23/03925/REG3

Address: Goole Market Hall Estcourt Terrace Goole East Riding Of Yorkshire DN14 5AB

Proposal: Erection of sub-station, switch room, bin store and associated landscaping to existing yard, new roof covering and replacement roof lanterns

Name: . Building Conservation

GMH-GGA-01-ZZ-DR-A-2104

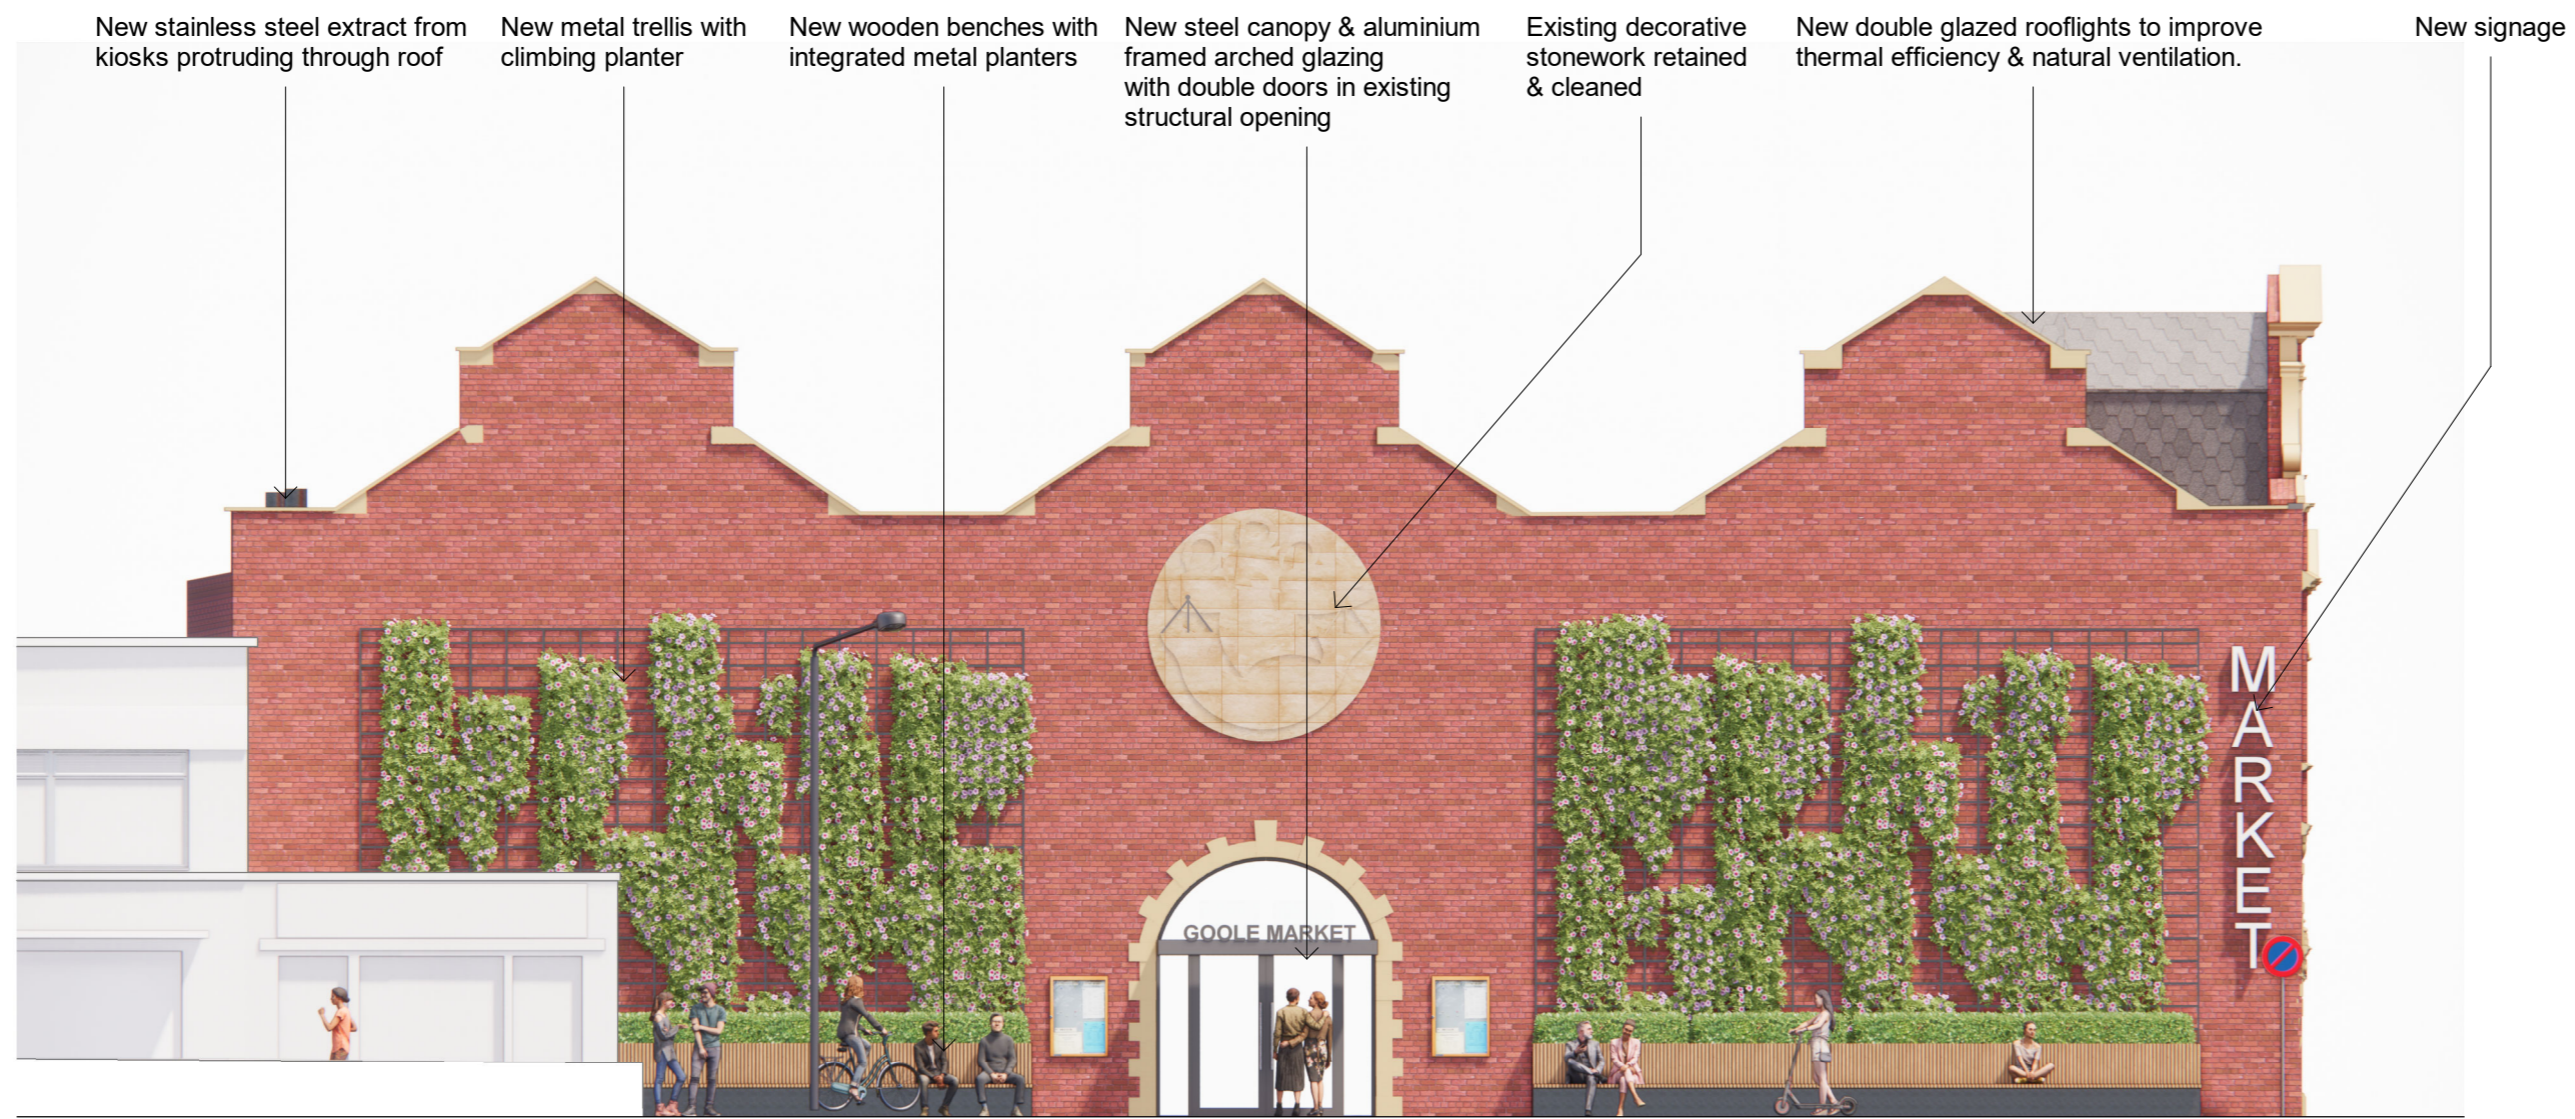
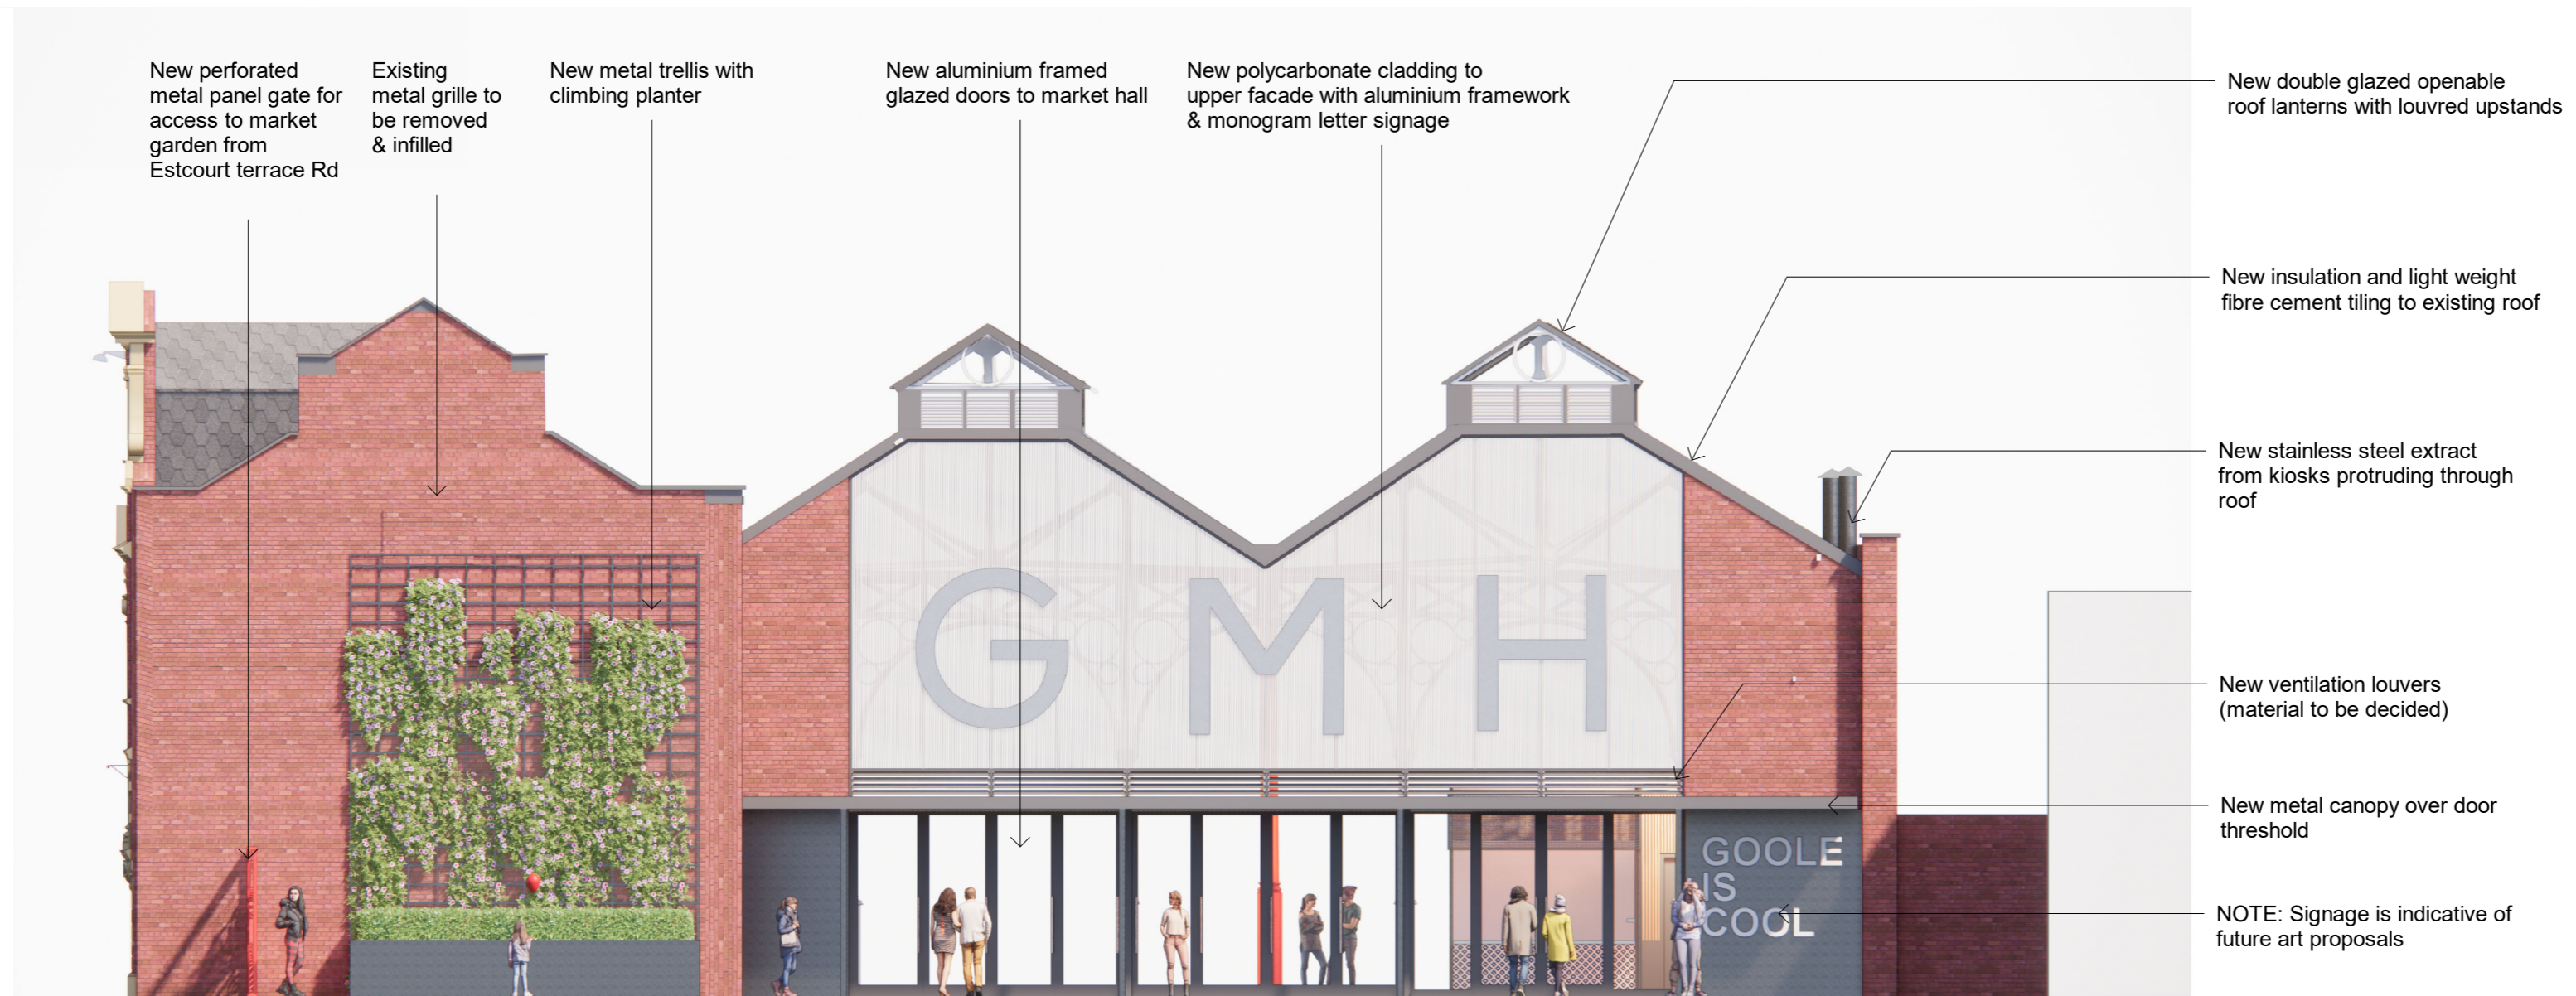
There are no concerns with the erection of a substation, switch room and bin store or the associated landscaping to the existing yard. The proposed landscaping would enhance this part of the conservation area. The proposals for the north elevation including replacing glazing to the ground floor, installing polycarbonate cladding to the first floor and erecting a metal canopy is supported. The north elevation is not the principal elevation and has already been altered as evident from the existing large area of glazing. The proposal for this elevation would be unlikely to alter the level of harm caused to the character and appearance of the conservation area.

Reopening an existing blocked over entrance on the east elevation is positive. This elevation holds the most interest historically and aesthetically. The retention of the original windows to the first floor combined with re-opening an entrance would enhance this part of the conservation area. There are no concerns with the proposal for the south elevation as little is changing.
